From: Michael Eastham <Michael.Eastham@arun.gov.uk>
Sent: 05 August 2020 14:59
To: Planning Scanning <Planning.Scanning@arun.gov.uk>
Subject: FW: Planning Consultation on: BN/57/20/DOC

Please see the email below from ADC Drainage Engineers regarding discharge of condition application BN/57/20/DOC for the Lillies, Yapton Road, Barnham.

Condition 6 – Surface Water Drainage Design

17748-BARN-5-SK003 A

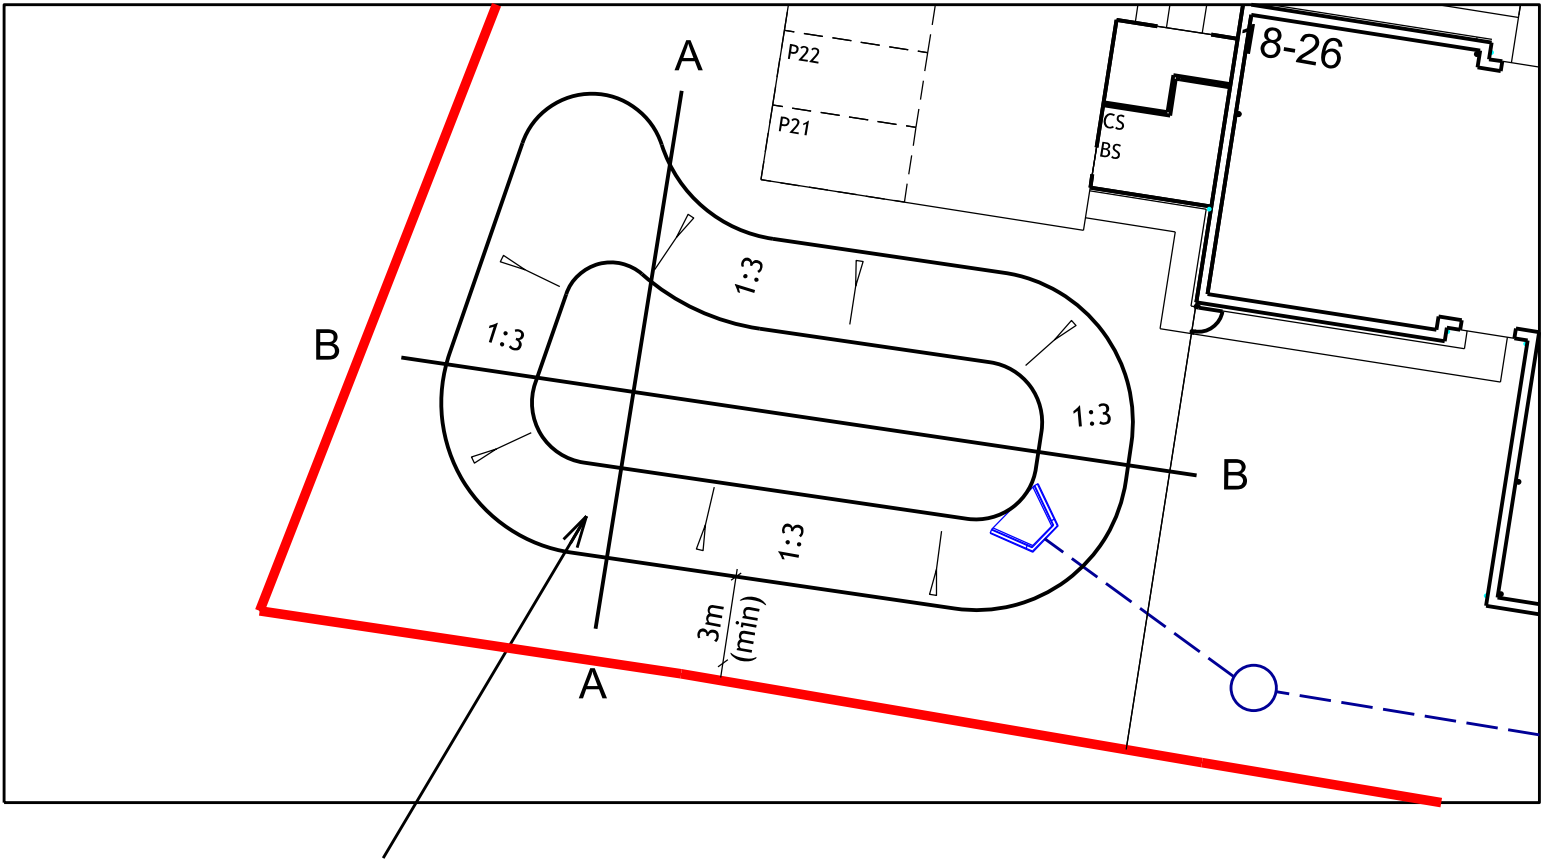
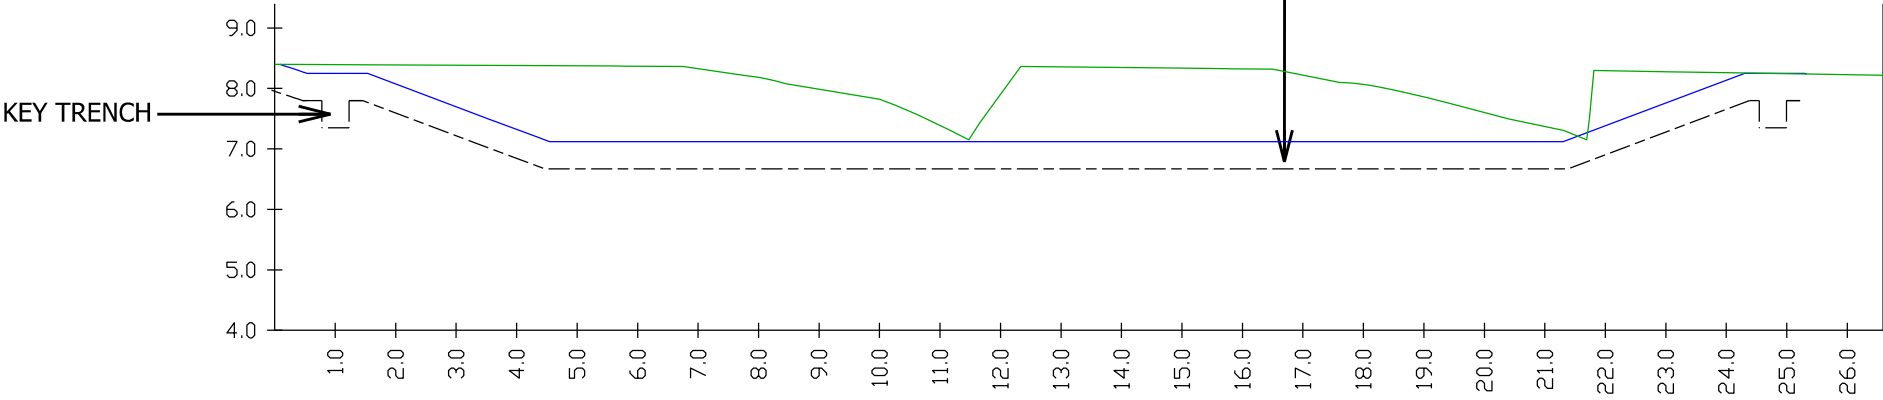
9. Pond cross section construction detail drawings are required- 2 sections required, perpendicular to one another. Details should include liner. *Details of the liner are as per the e-mail correspondence to Paul Cann. Attached* Please provide details of what liner is proposed, or a specification that the liner must achieve if a specific liner is yet to be selected. Detail shown on drawing.

10. Flotation calculations required. Please provide winter groundwater monitoring October- March. Otherwise, assume groundwater is at surface. *Refer to the comments provided in the e-mail chain below.* Please supply calculations. If monitoring has been completed October to March inclusive you can use observed groundwater levels, without this you must assume a worst case. You will note that in correspondence with Paul Cann he stated "Winter groundwater monitoring was undertaken on the development site immediately next door to the west. They encountered standing groundwater levels between 600mm and 1000mm deep which is comparable to our knowledge of Barnham. In fact levels can be much higher." Your attention is directed to where he states that in fact levels can be much higher,

If you do assume a dry pond and groundwater at finished ground levels, you'll need sufficient soil above the liner to equal 188m3 of water (pond volume), ie 188 tonnes.

With soil at 2 tonnes/m3 this means 94m3 of soil are required - for a 248m2 pond area the soil thickness over the liner will need to be about 380mm thick throughout. Please provide the supporting calculations, I have not seen these to date.

PERMEABLE BLOCK PAVING CONSTRUCTION

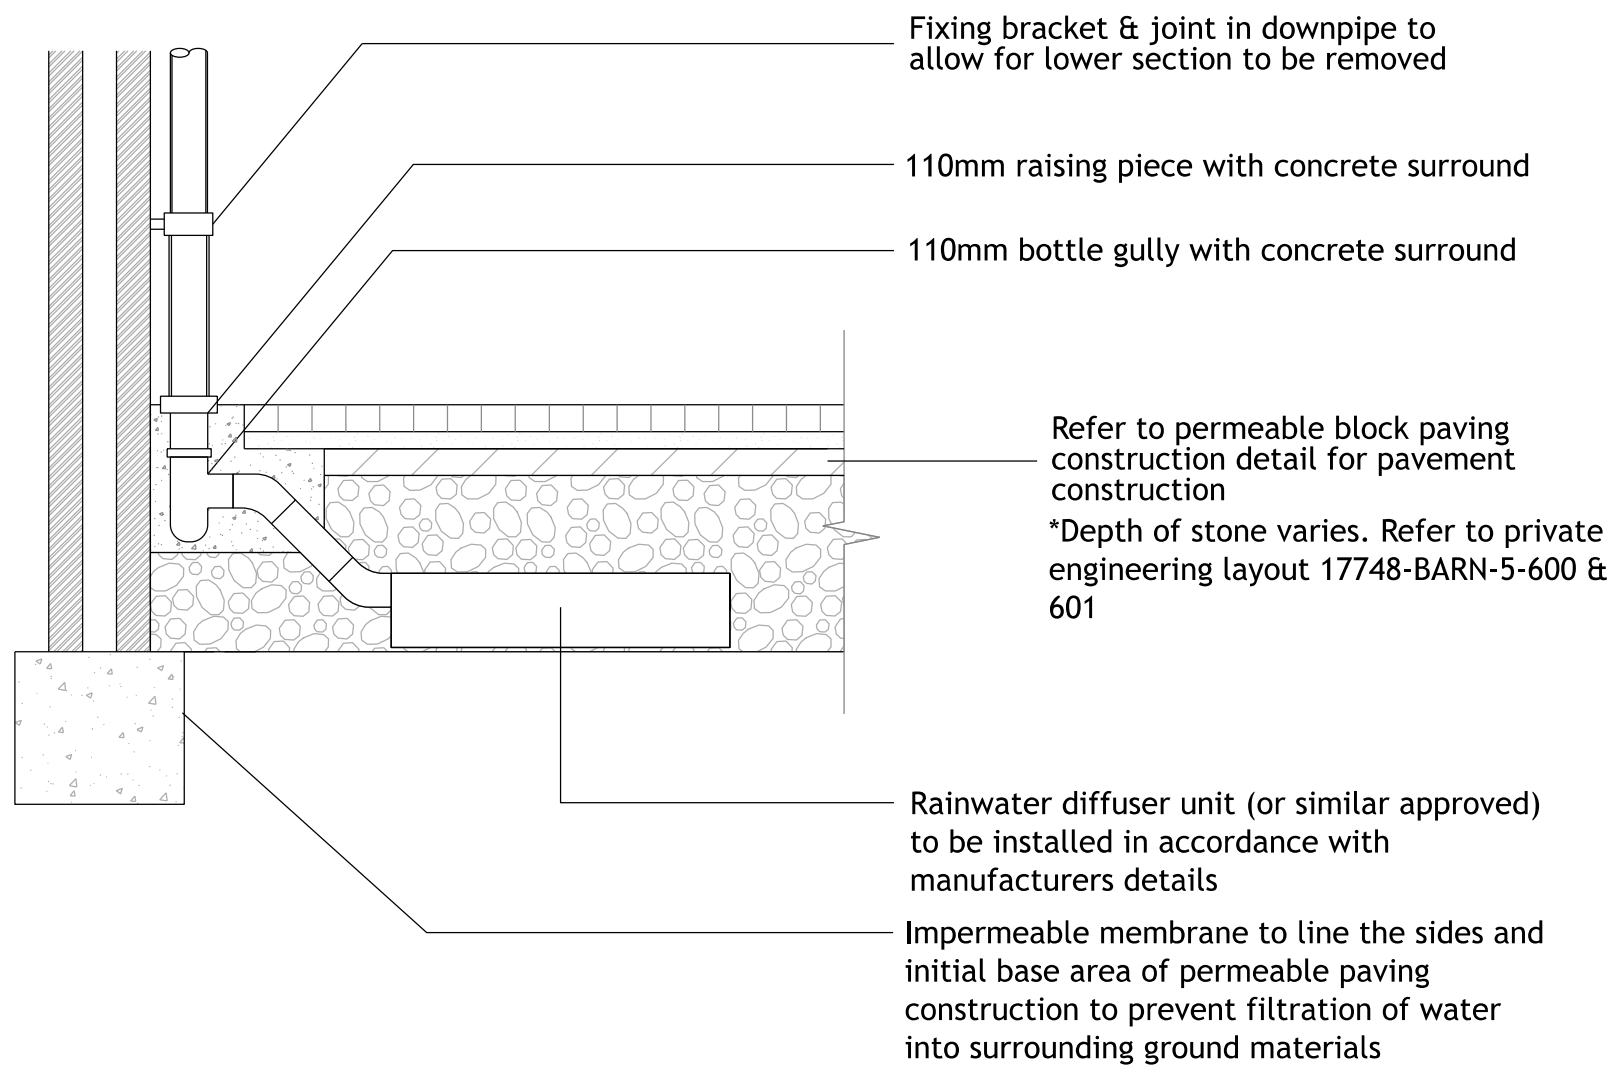
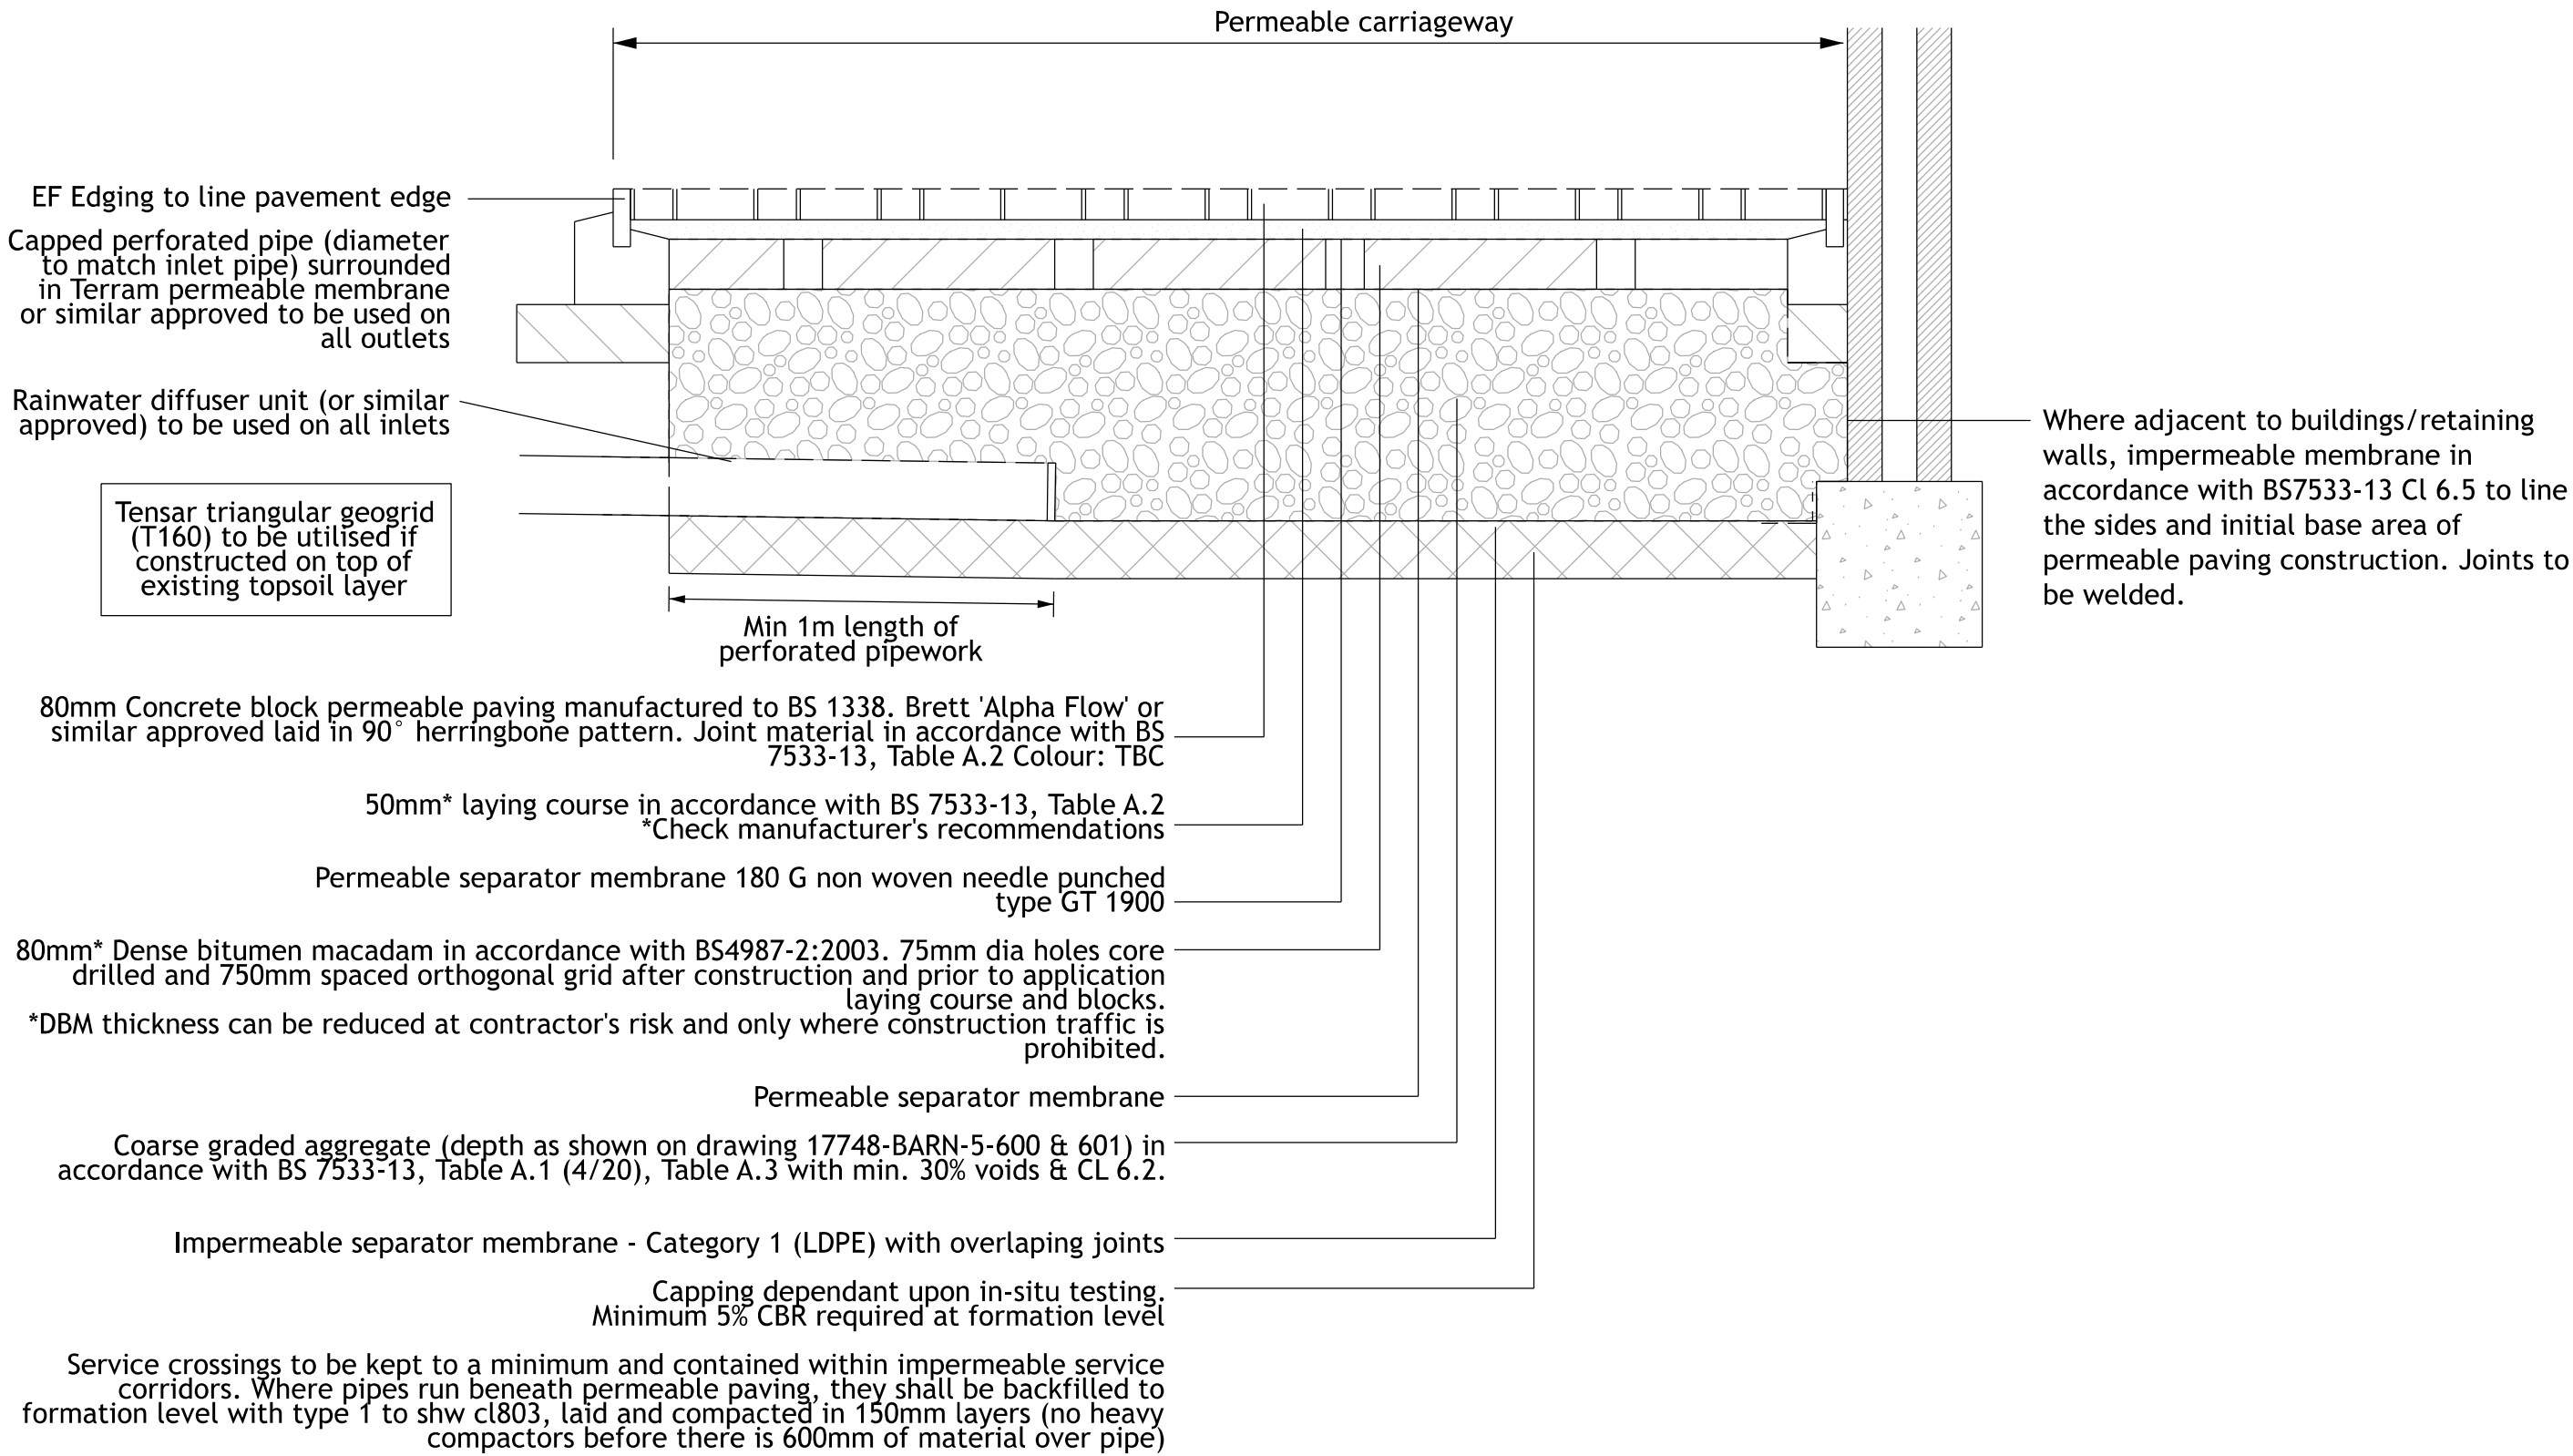
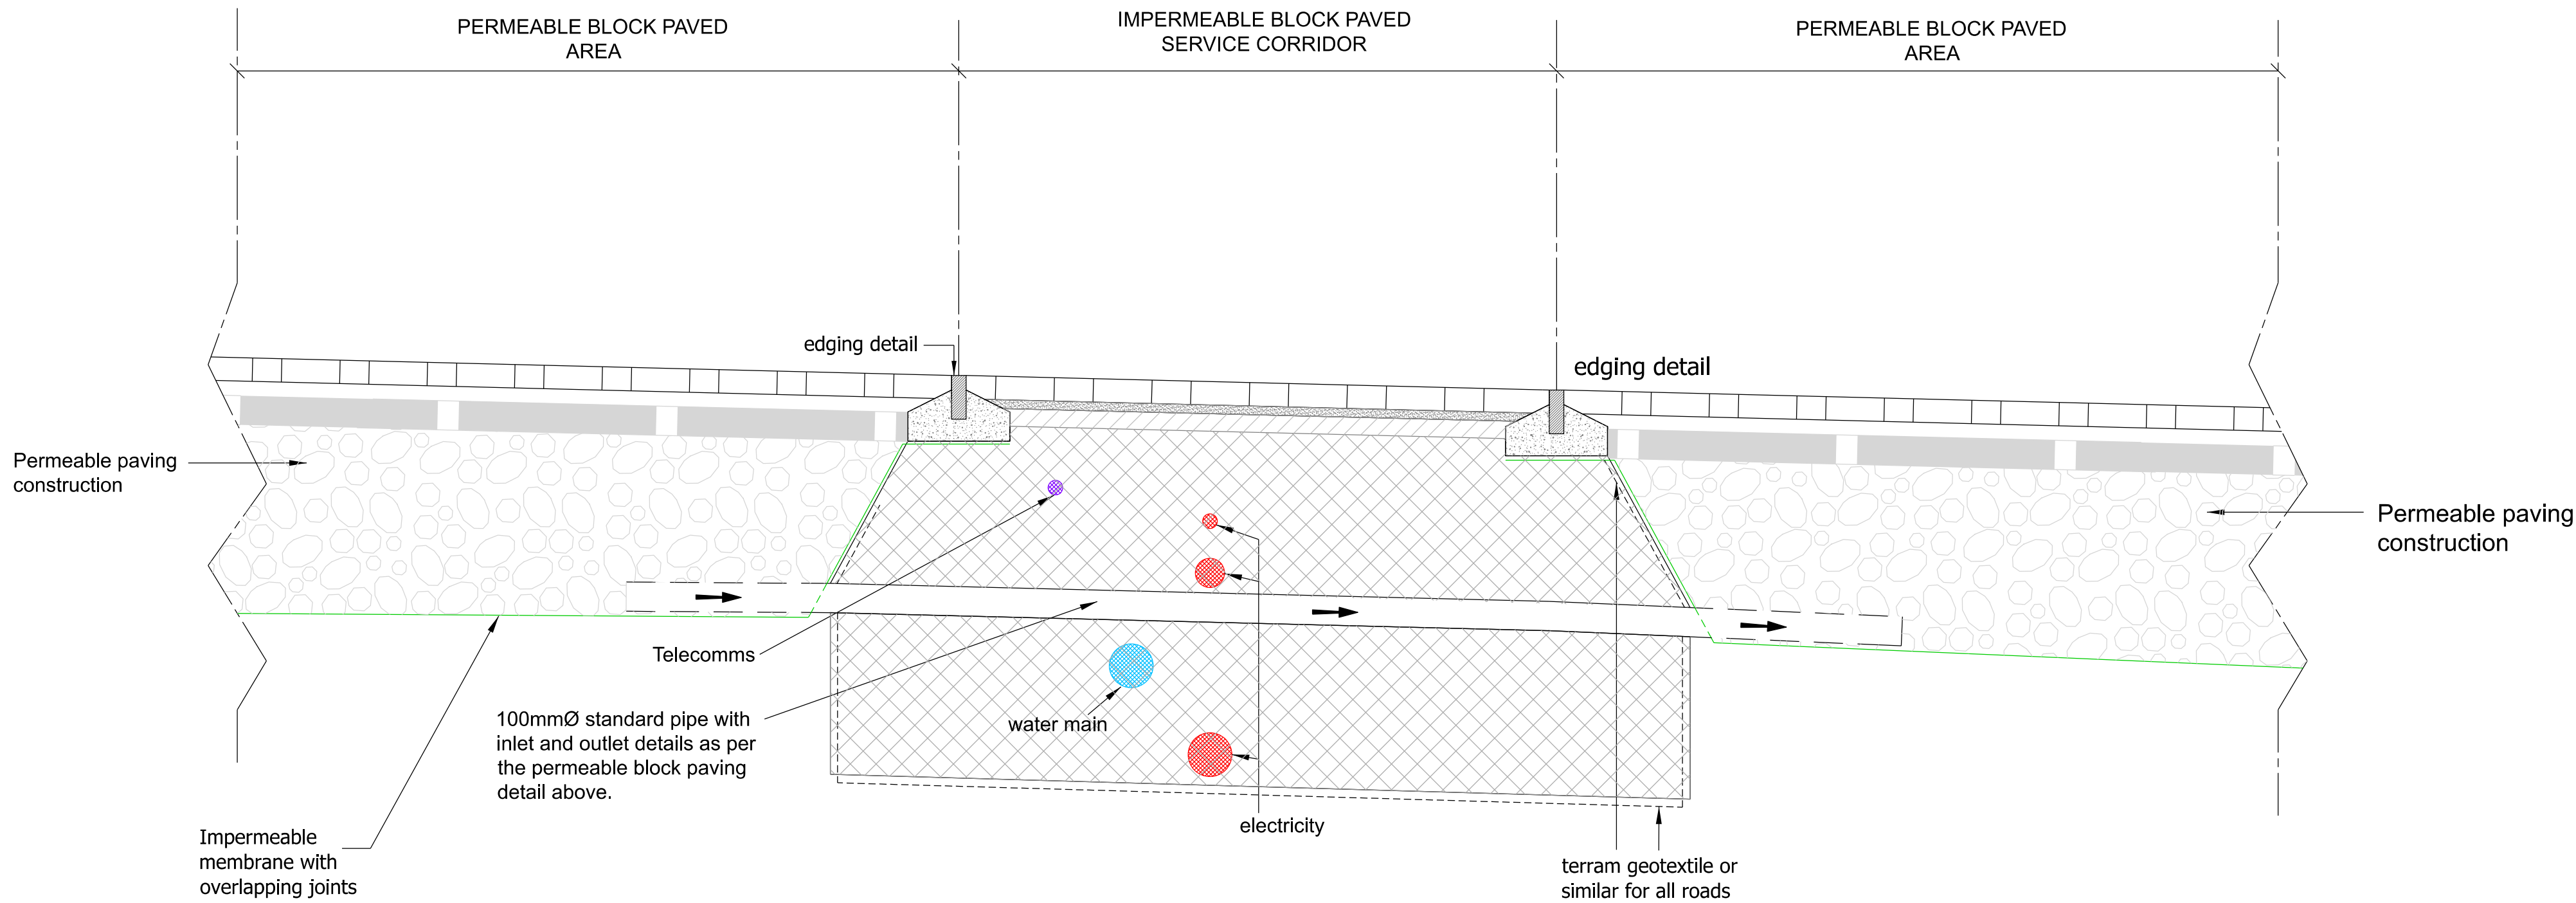
14. Include invert levels and dimensions of connecting pipes between permeable paving areas. For example the link pipe between M4 permeable paving areas near plots 7 and 6 does not have a diameter or upstream invert level. *This is shown on the private permeable paving construction details Drawing 17748-BARN-5-921 and dealt with in correspondence with Paul Cann. Drawing not included on planning website or in correspondence regarding this DOC application, please provide, all documents must be publically available and be able to be referenced in any approvals. Awaited*

15. Detail how water will flow between sub-base either side of service corridor construction for foul sewer. *This is shown on the private permeable paving construction details Drawing 17748-BARN-5-921 and dealt with in correspondence with Paul Cann. Drawing not included on planning website or in correspondence regarding this DOC application, please provide, all documents must be publically available and be able to be referenced in any approvals. Awaited*

22. Permeable paving construction detail drawing required. *Drawing 17748-BARN-5-921 Please supply details, as stated previously by others sufficient information to ensure construction has been completed in accordance with approvals is required. Awaited Drawing not included on planning website or in correspondence regarding this DOC application, please provide, all documents must be publically available and be able to be referenced in any approvals.*
